Norwich to Tilbury NSIP Examination - Deadline 6

Colchester City Council's Responses to Action Points from ISH3 and ISH4, the Rule 17 letter, plus comments on D5 submissions.

Norwich to Tilbury
Figure: 7.12.F106_VP4.08e(ii)
Viewpoint 4.08: Fordham

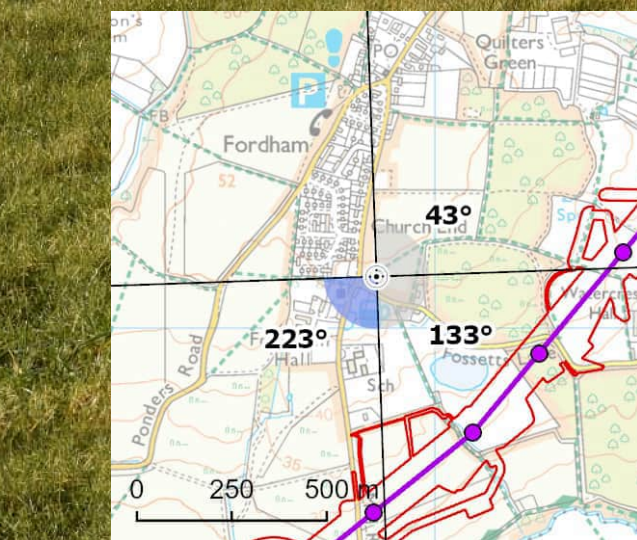
Figure: 7.12.F106_VP4.08e(ii) Fordham is materially worse.

Norwich to Tilbury
Figure: 7.12.F109_VP4.11e(ii)
Viewpoint 4.11: PRoW south of Aldham (Aldham 15)

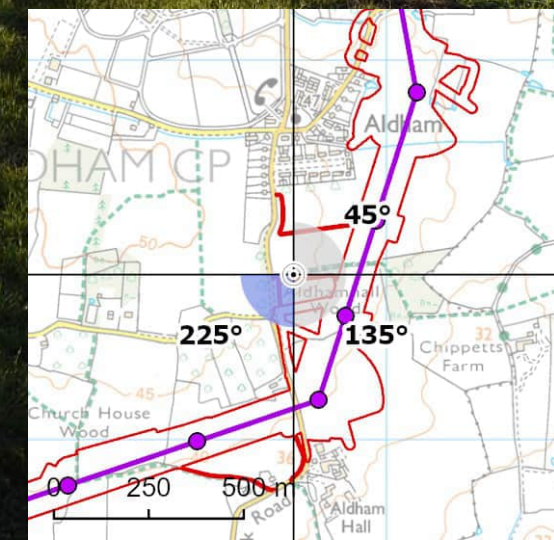
Figure: 7.12.F109_VP4.11e(ii) south of PRoW Aldham 15 is very clearly materially worse.
